22 Hillside, Hatherden, SP11 0HP – Construction of a new dwelling

Design and access statement

This proposal was previously considered under Pre-application 21/02989/PREAPN, refused under planning application 22/00992/FULLN, refused under planning application 22/01967/FULLN, and considered under Pre-application 23/00500/PREAPN and 23/01236/PREAPN where the following concerns were raised:

Proposed site plan 1:200

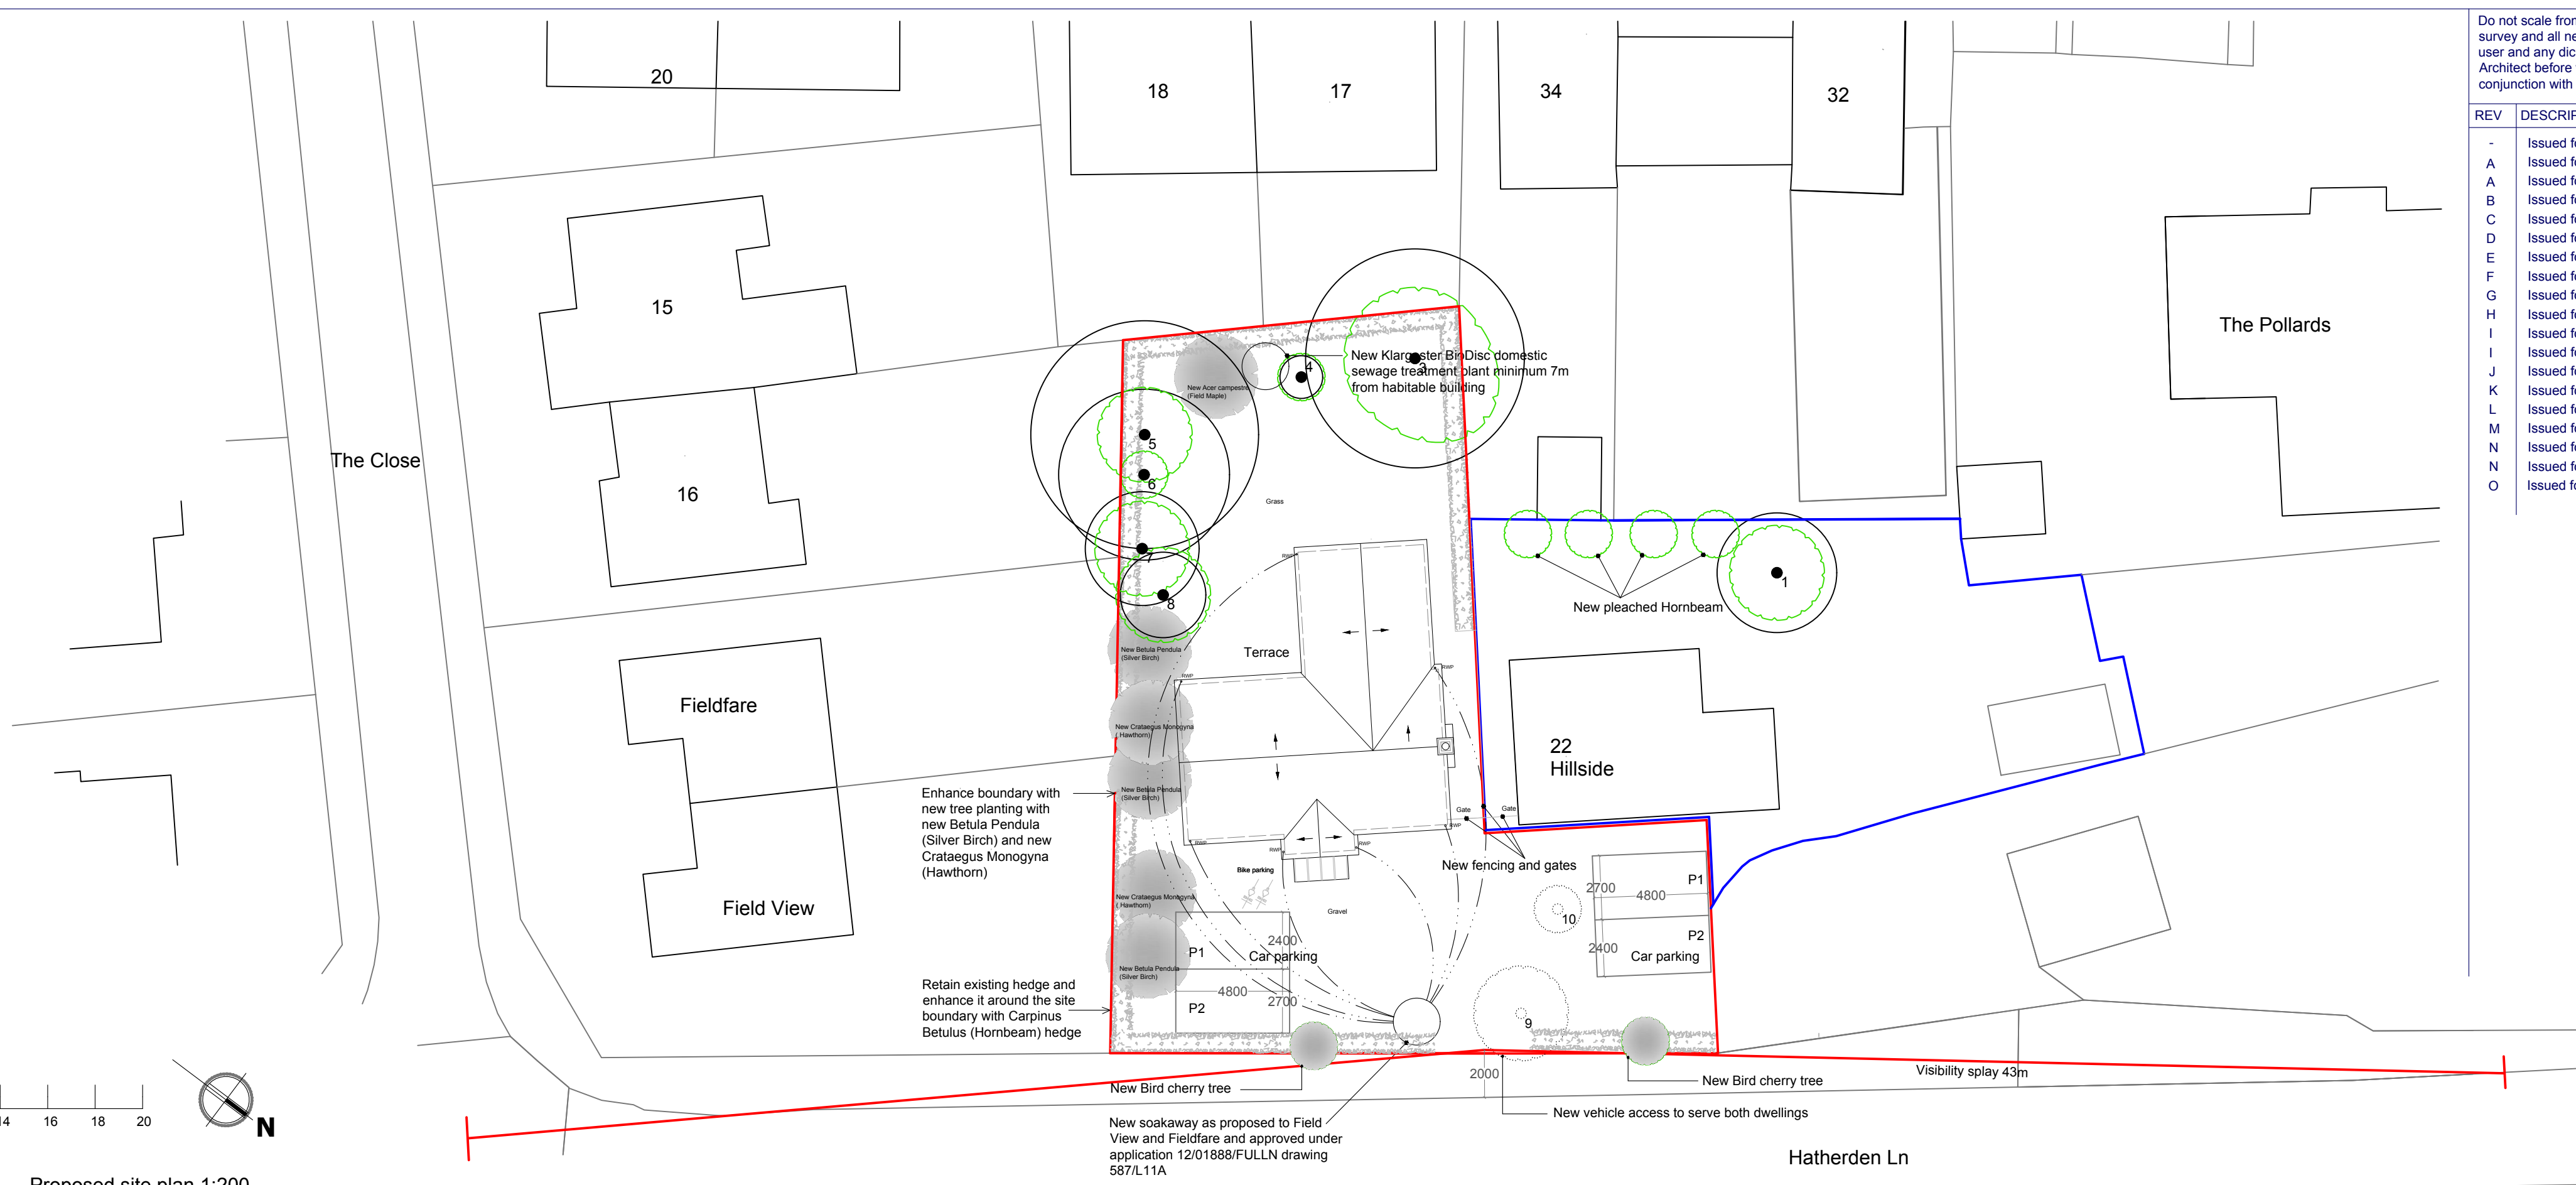
1. Comment: *'We would recommend details of 1 for 1 replacement tree planting to be included with any future planning application to replace the small trees proposed to be felled within the front garden of Hillside to accommodate the parking.'* Response: Two Bird Cherry trees are proposed to replace T9 and T10; four pleached Hornbeam have also be planted at the back of 22 Hillside to replace the loss of the T2. An updated Arboricultural report forms part of this application.

South elevation

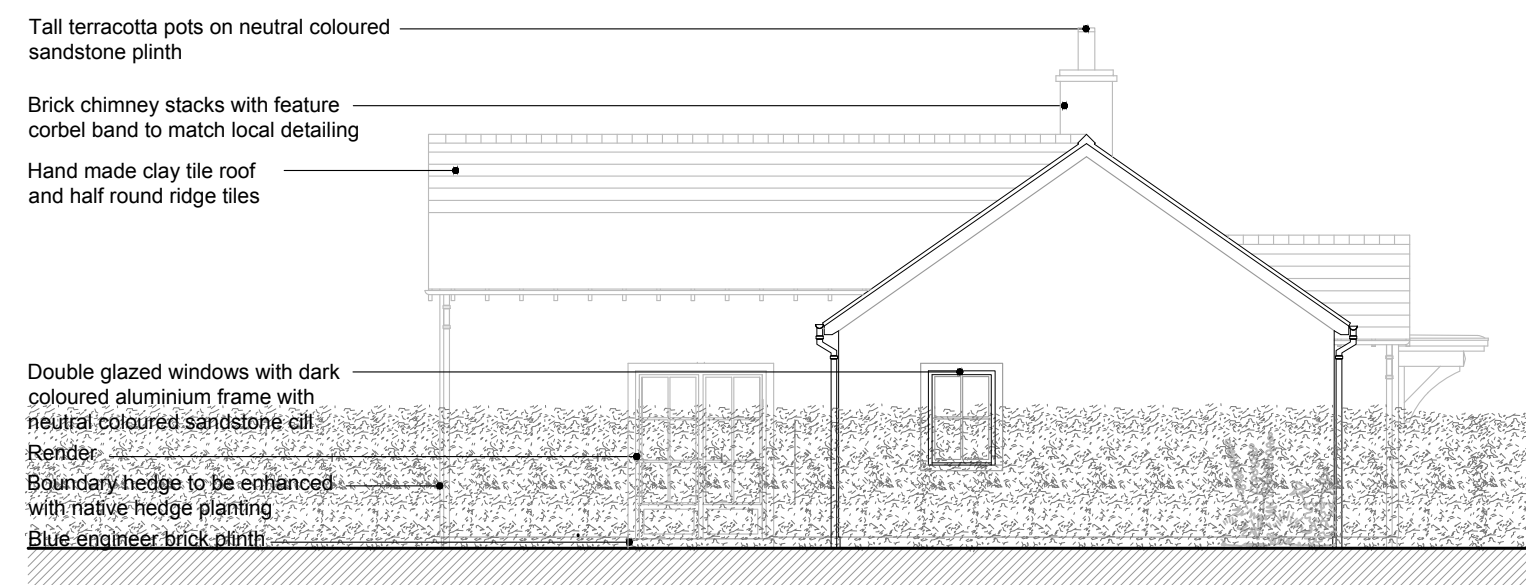
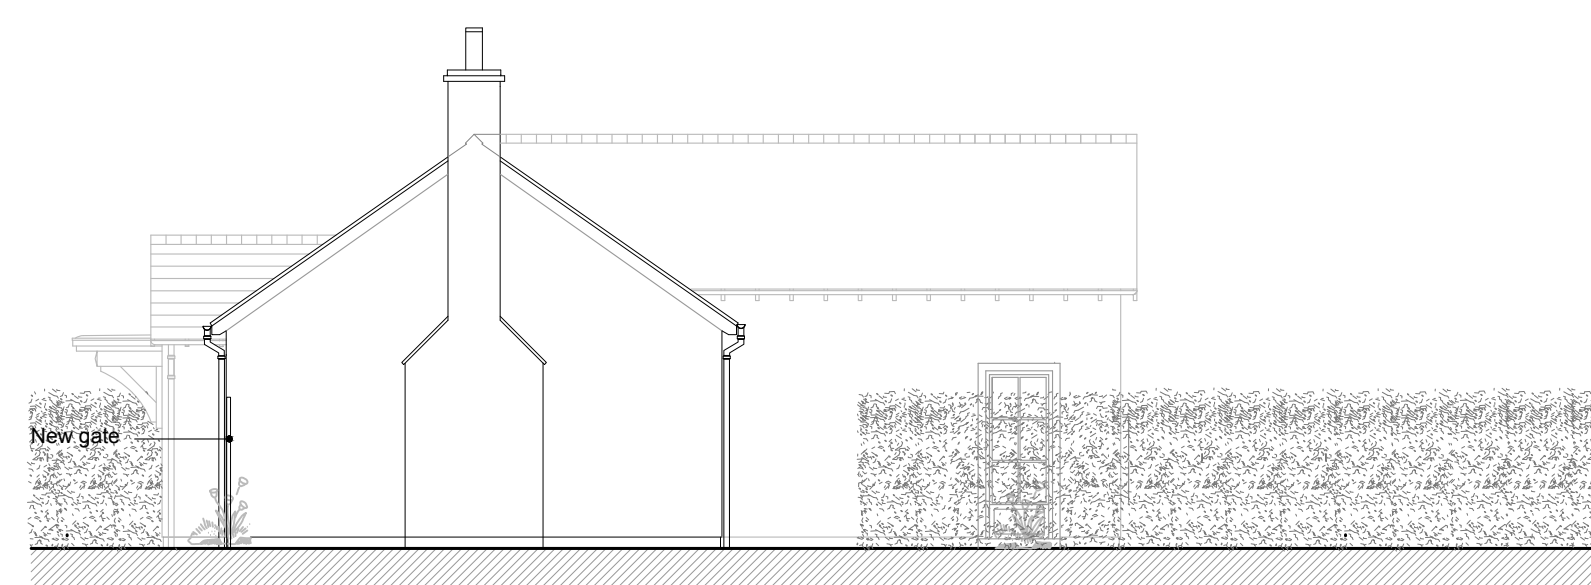
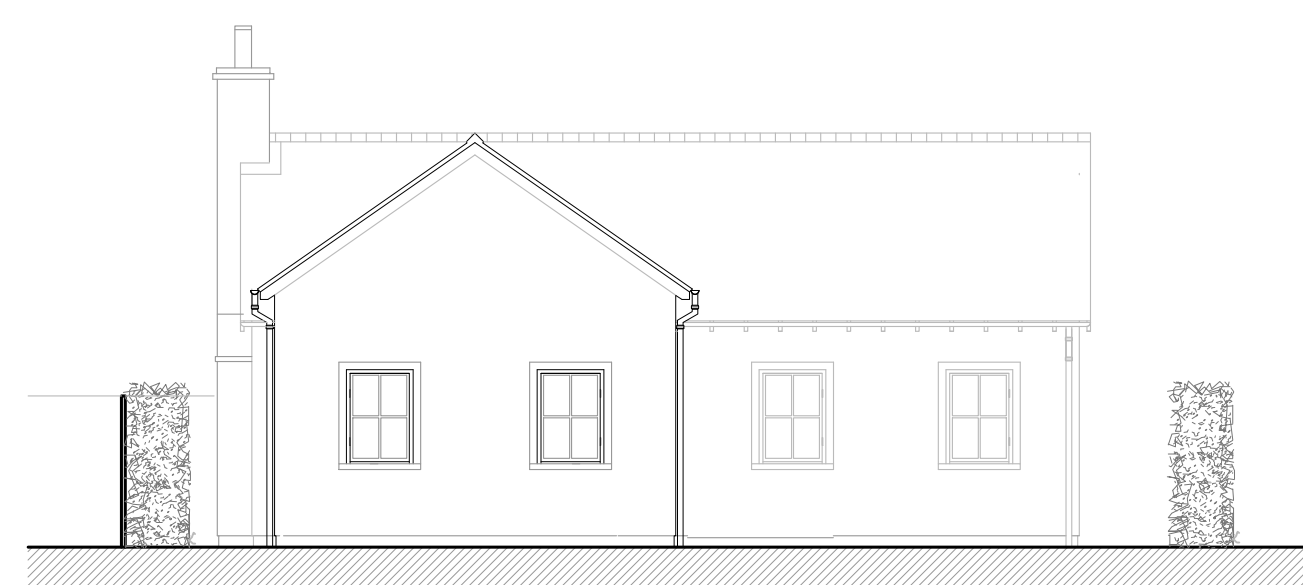
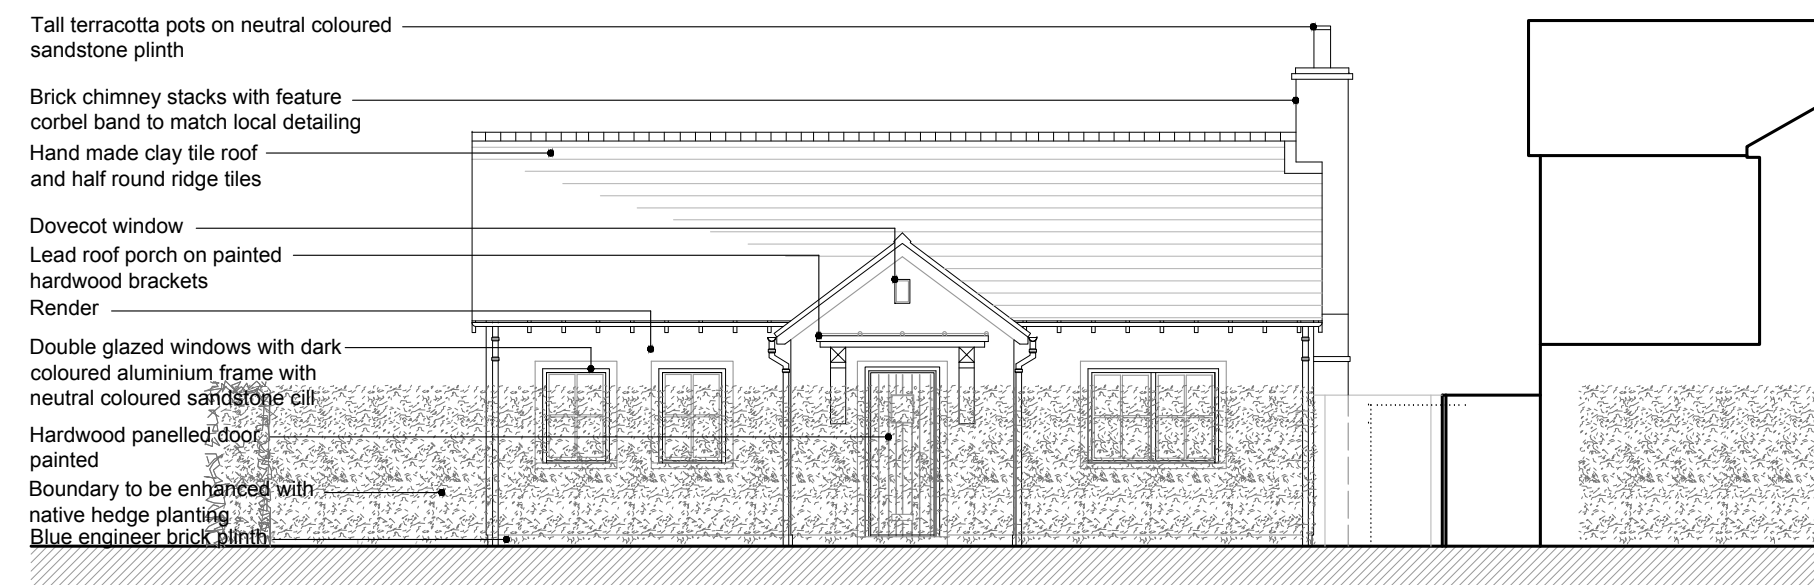
2. Comment: *'a reduction in height of the proposed dwelling to single storey could create a more sympathetic development.'* Response: we have omitted 1st floor accommodation, lowered the eaves, omitted the dormers and reduced the chimney stack all to reduce the mass of the building. The floor to ceiling height is 2300mm which is a modest height, and the roof pitch is 35 degrees which is the minimum for a reasonable quality clay roof tile.
